A303 Amesbury to Berwick Down

**8.59 – Proposed Changes Position Statement
(including Responses to Comments received on the
Proposed Changes Consultation Report (Non-Statutory))**

Proposed Changes Position Statement (including Responses to Comments Received on the Proposed Changes Consultation Report (Non-Statutory))

Version	Date	Status of Version
Rev 0	25.09.2019	Deadline 9 Issue

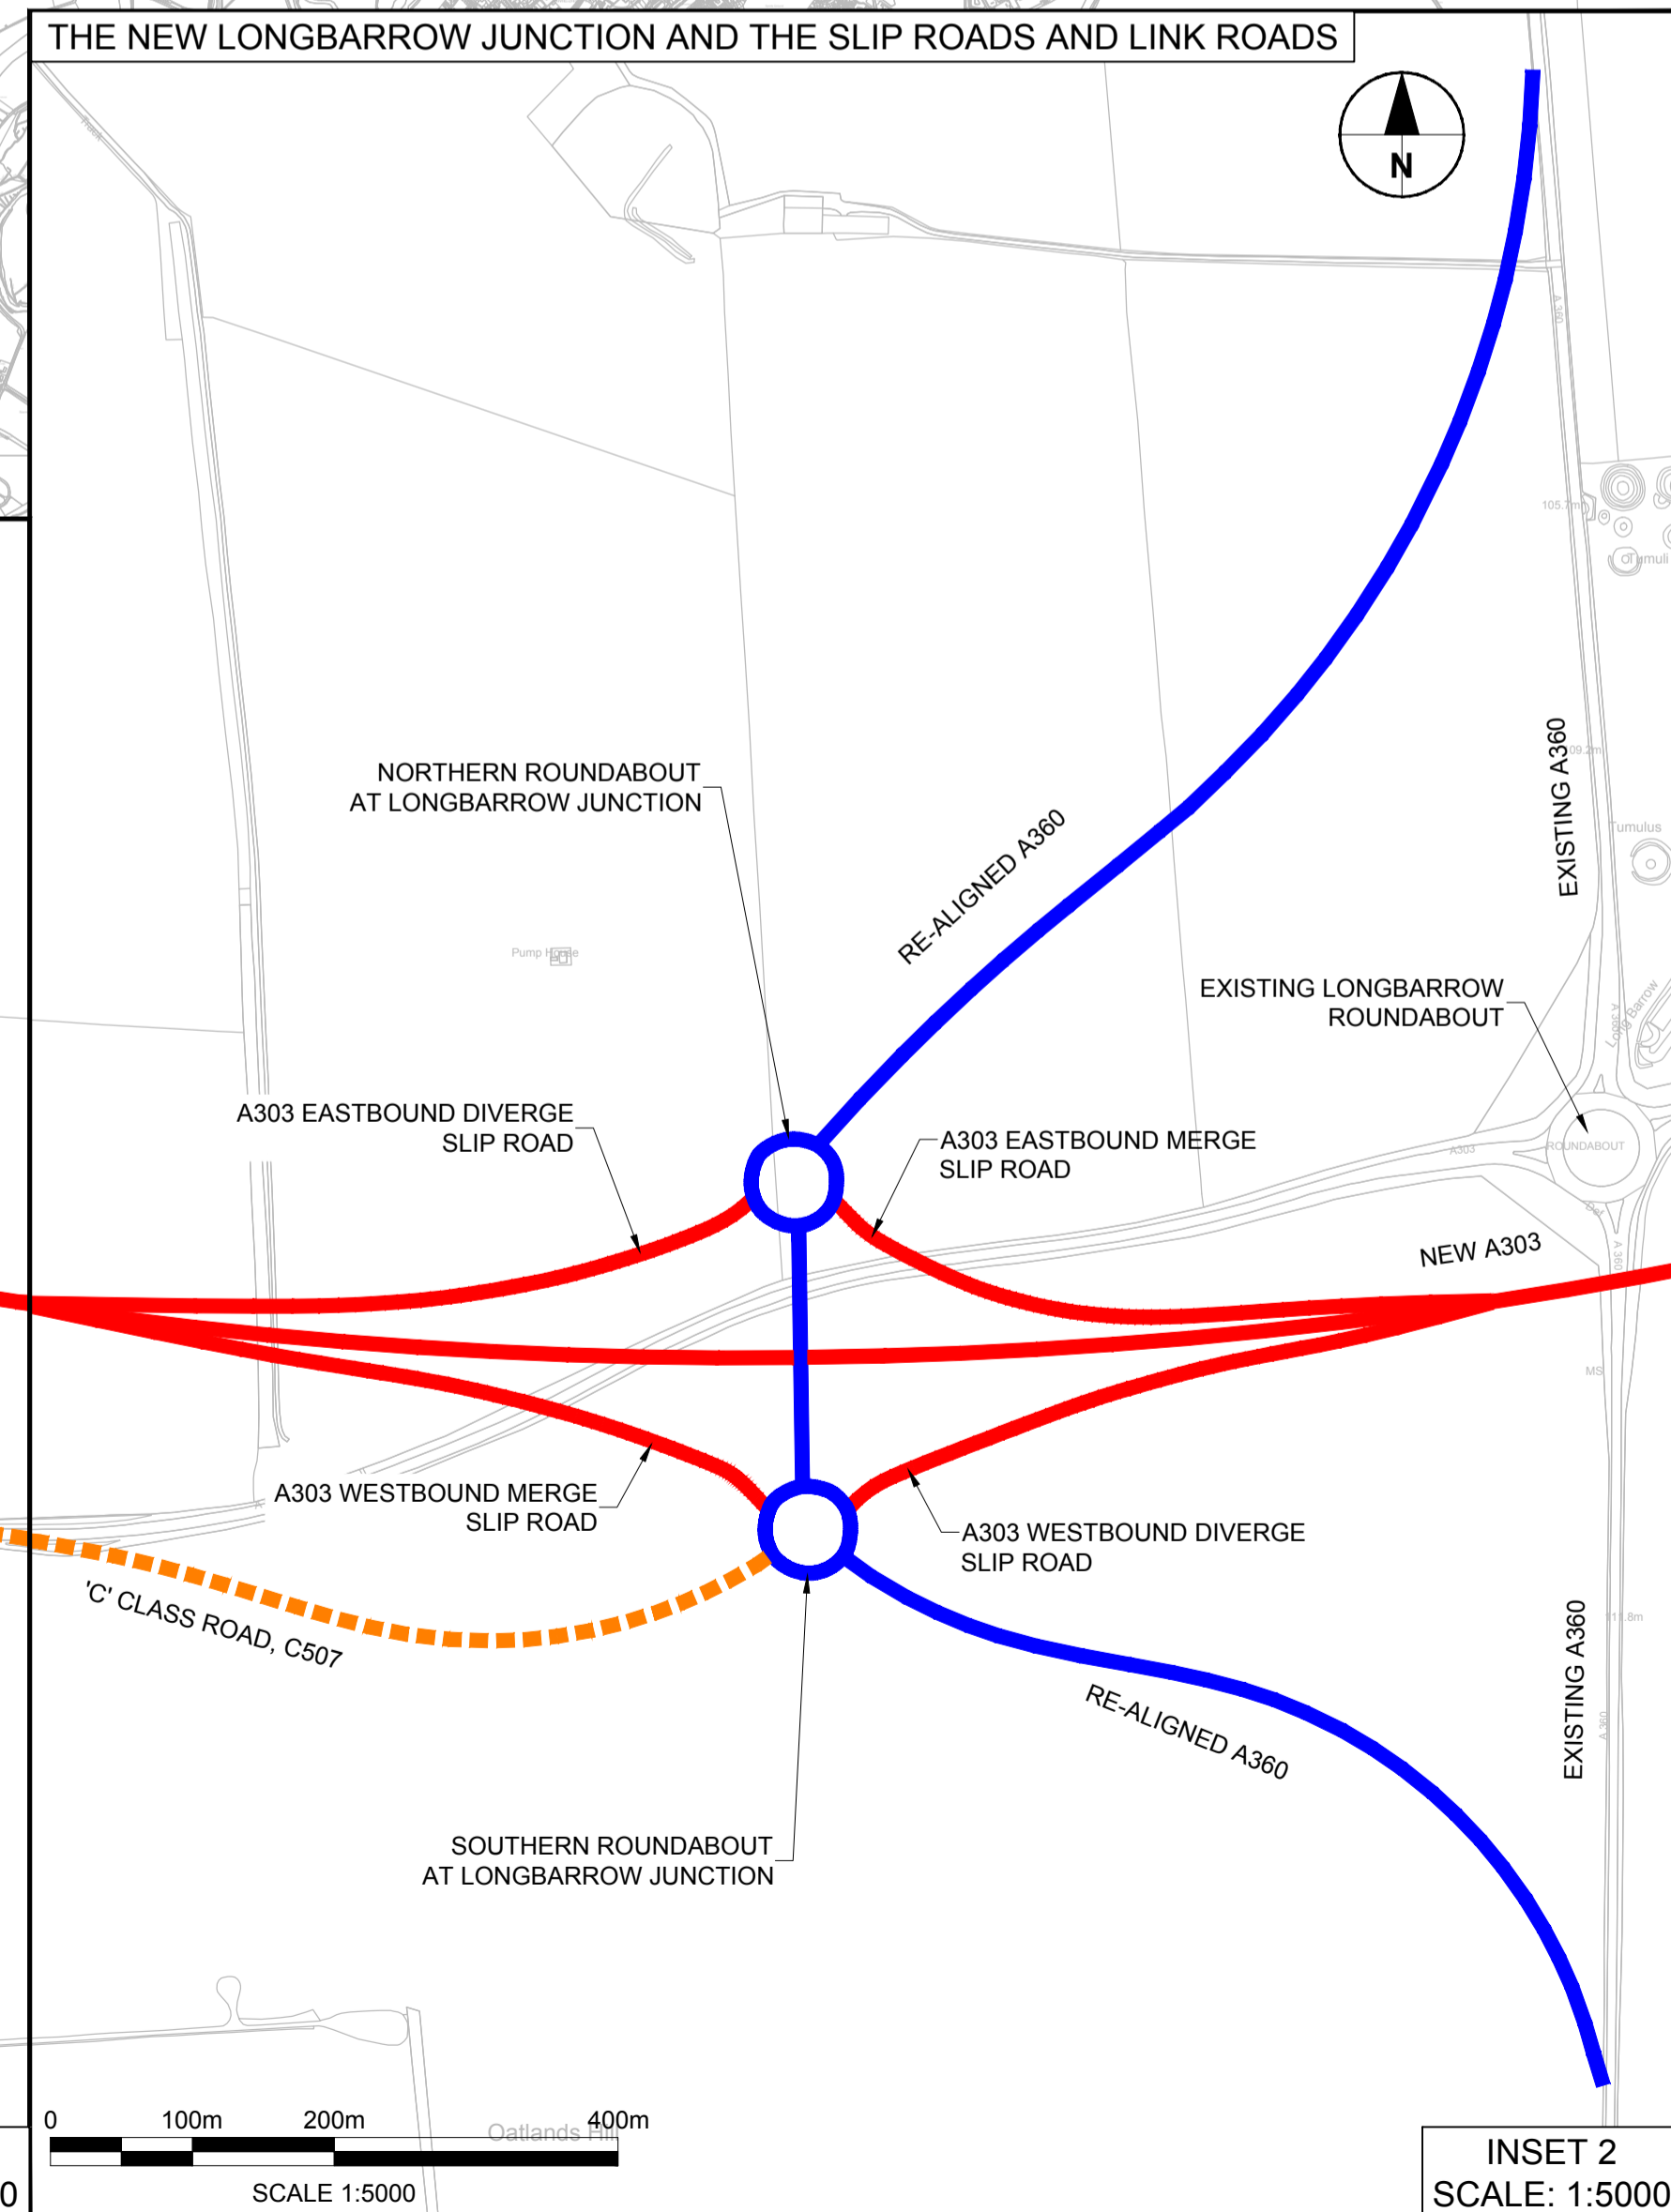
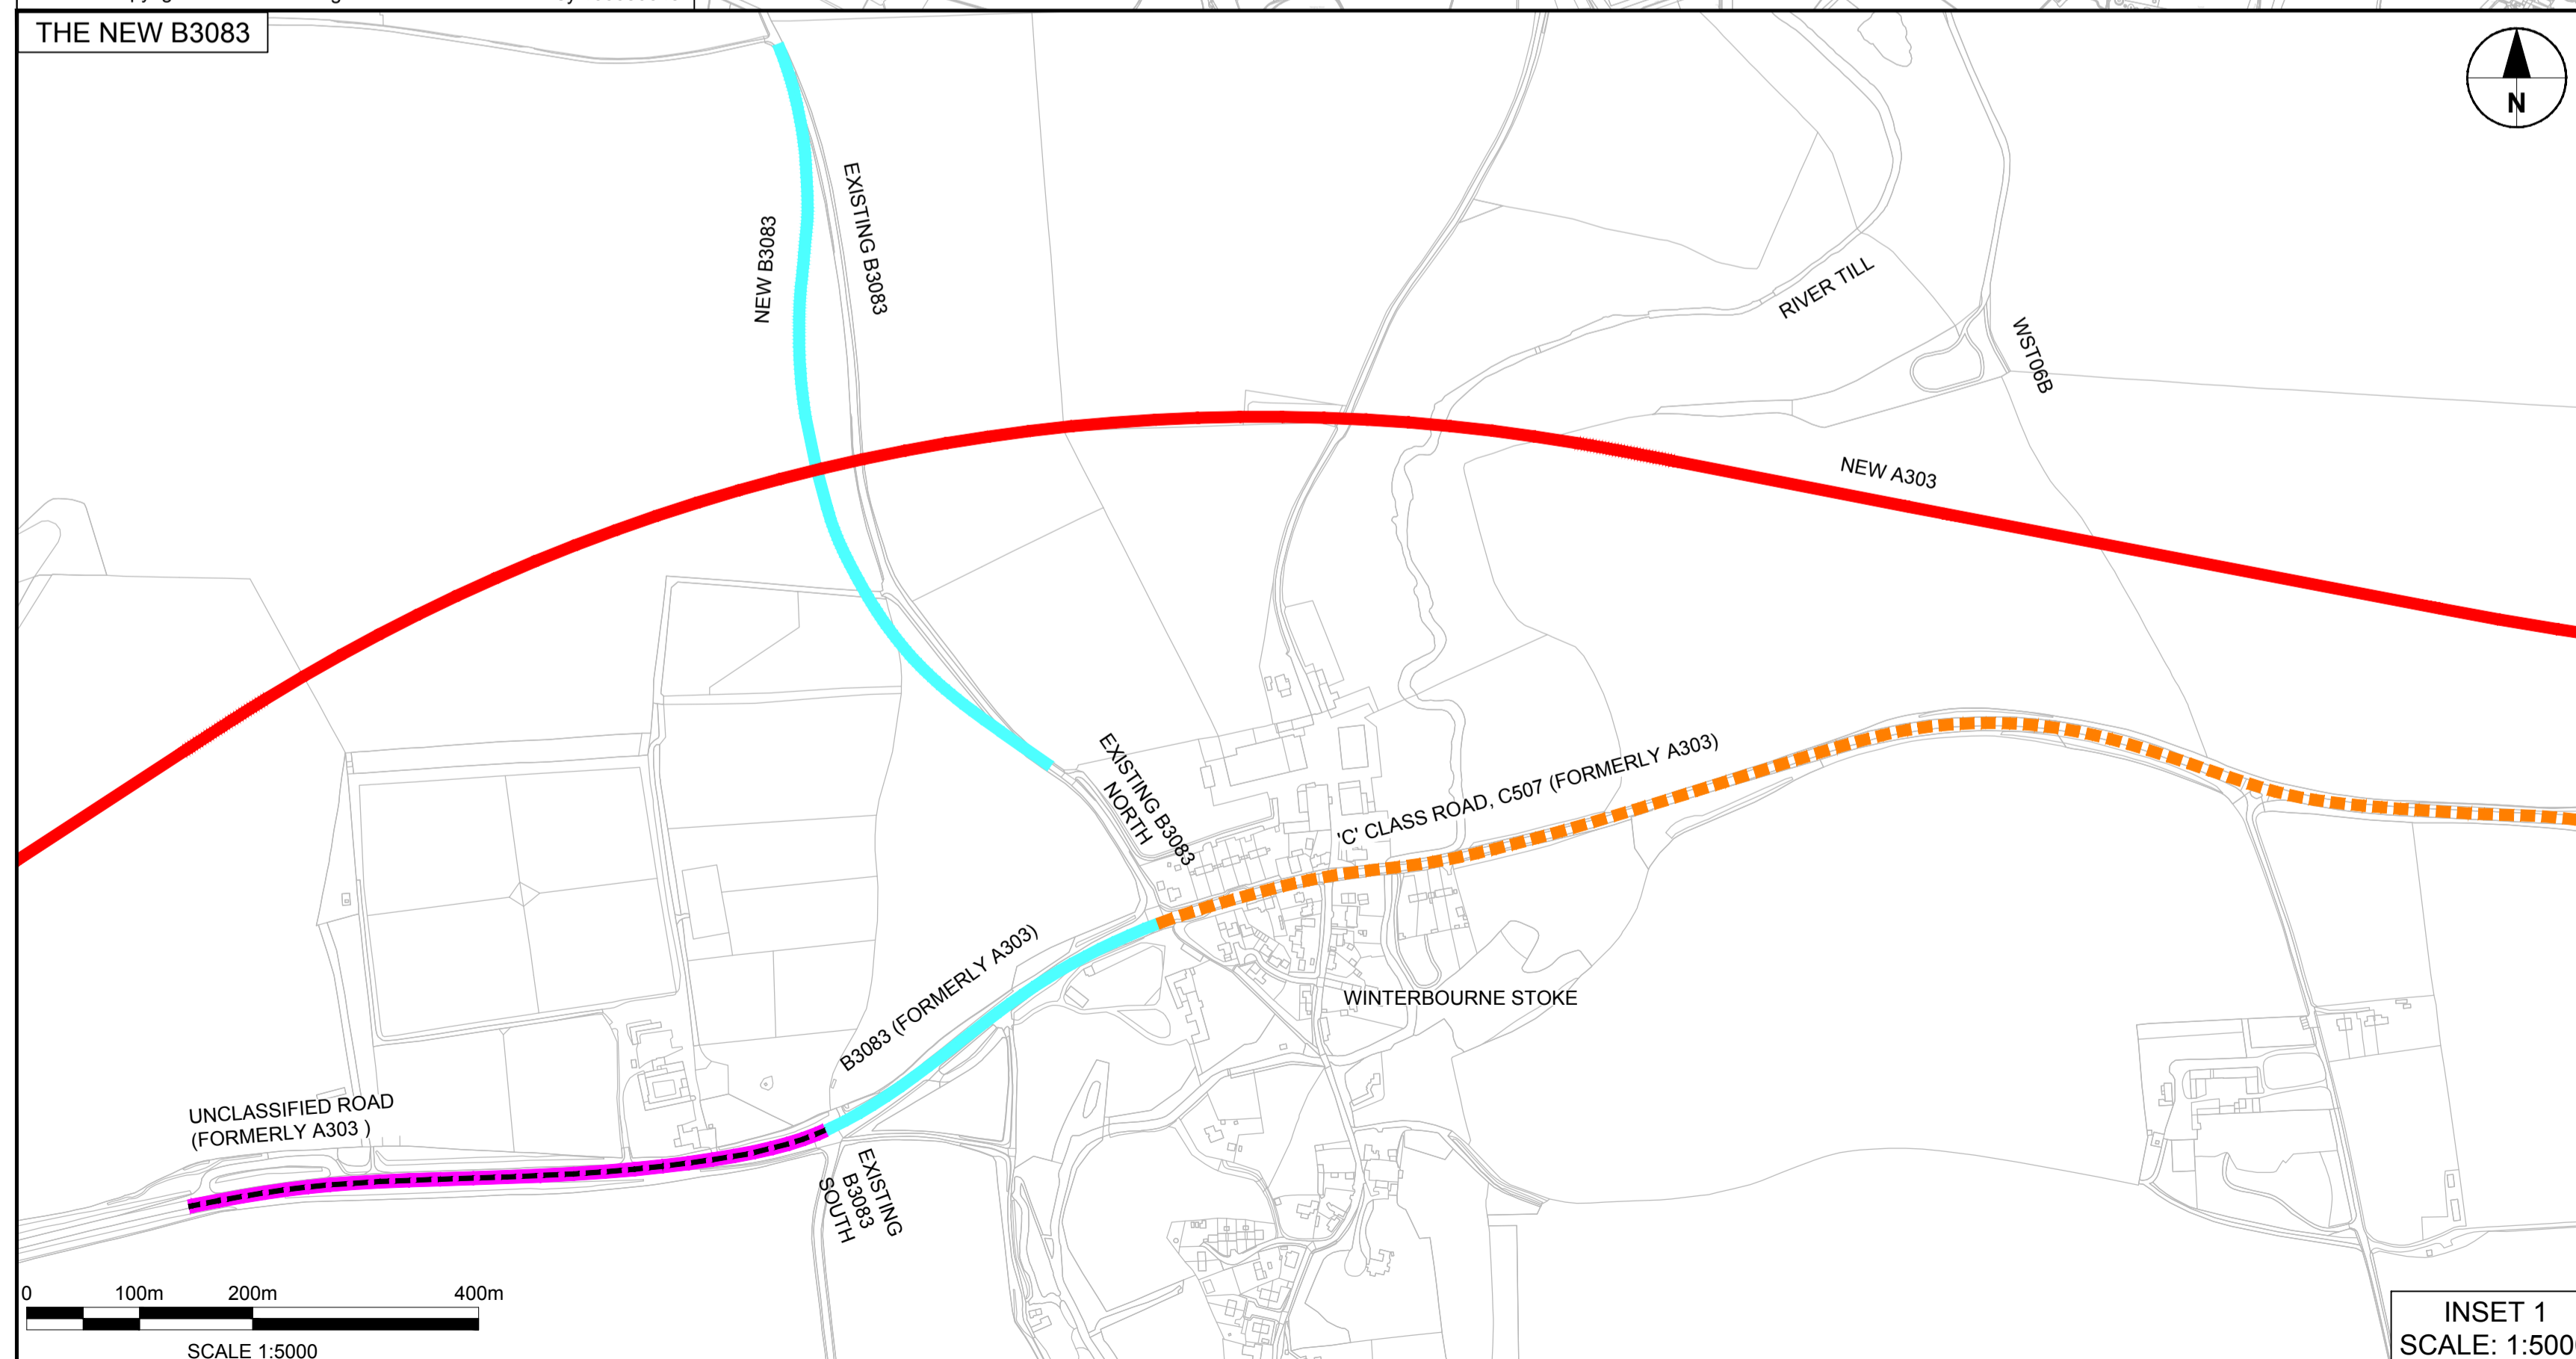
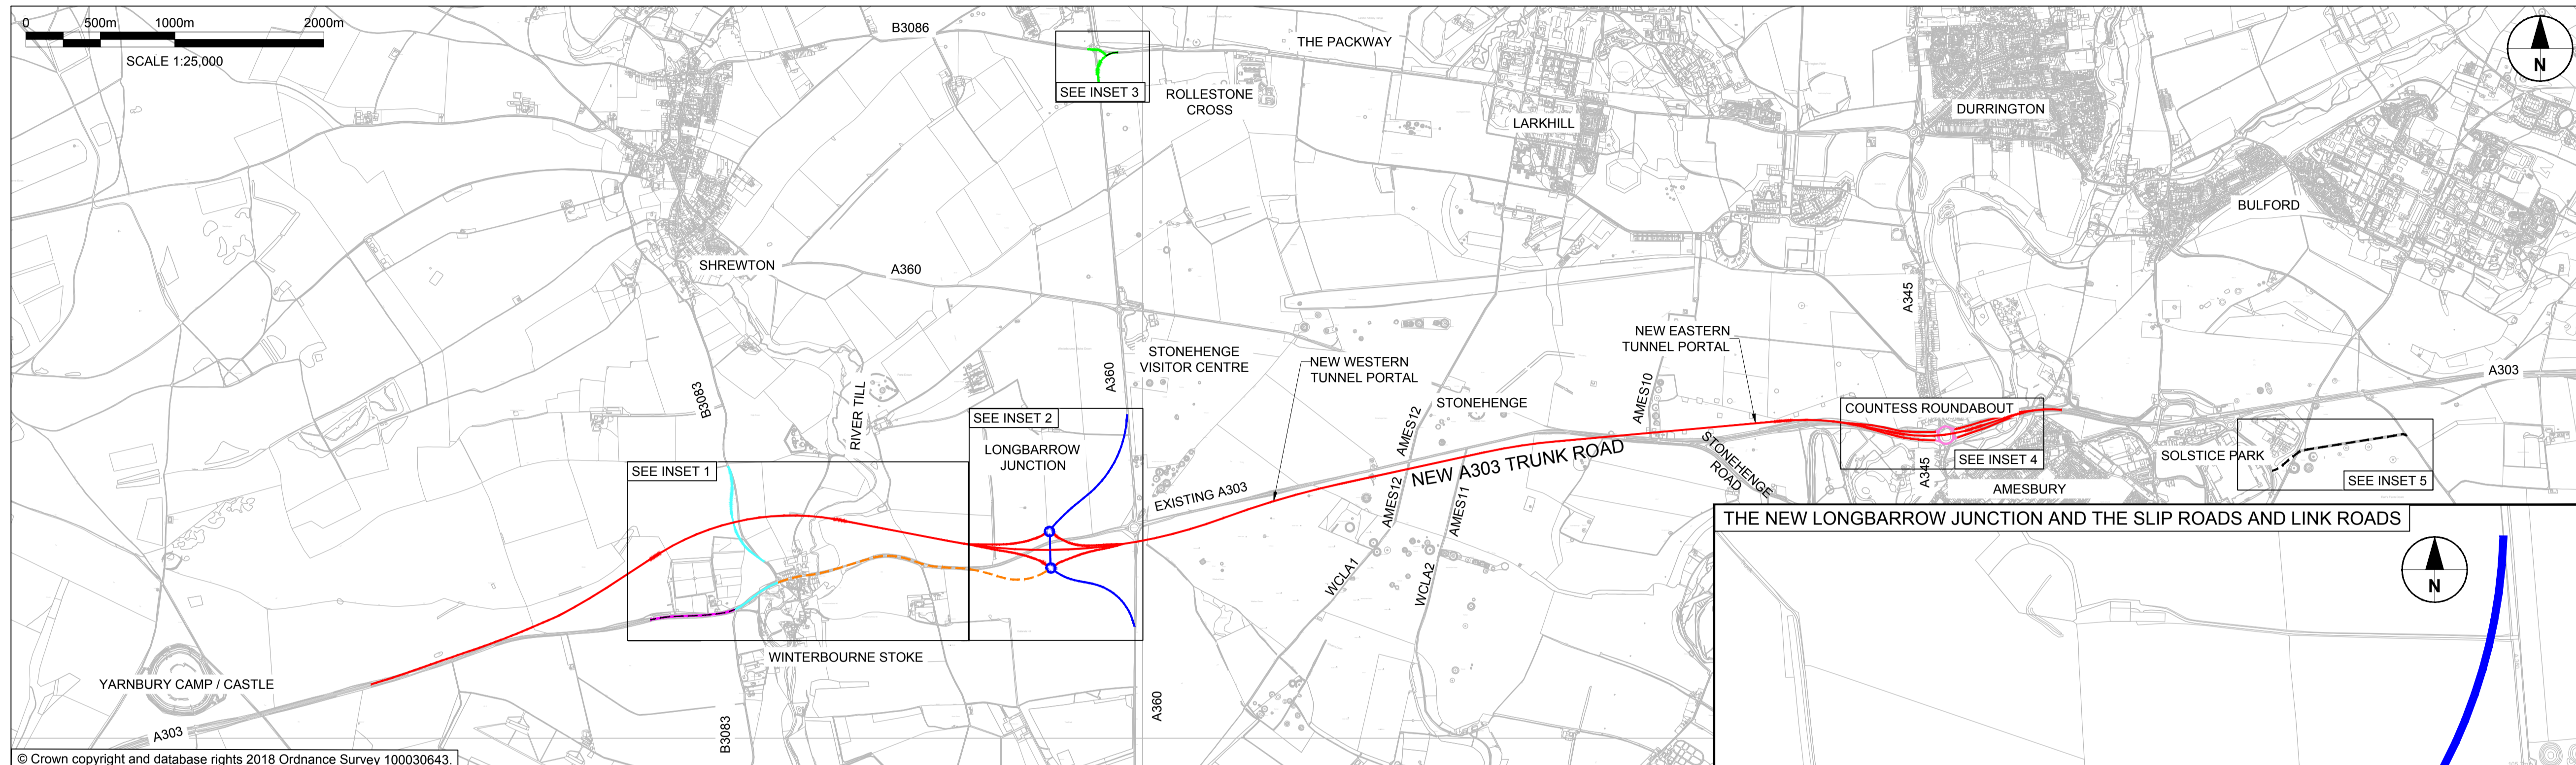
- 3.2.3 Only one of the five Deadline 8a respondents, Waves Training Solutions Limited on behalf of Mr FWG Whiting, had not previously responded to the proposed changes consultation. Mr Whiting's Deadline 8a comments related to NMC-01 (the proposed closure of the lay-by) and NMC-03 (the proposed change to the re-classification of part of the existing A303). Mr Whiting's comments, and Highways England's related responses, are set out in Table 5-1 in Chapter 5 below.
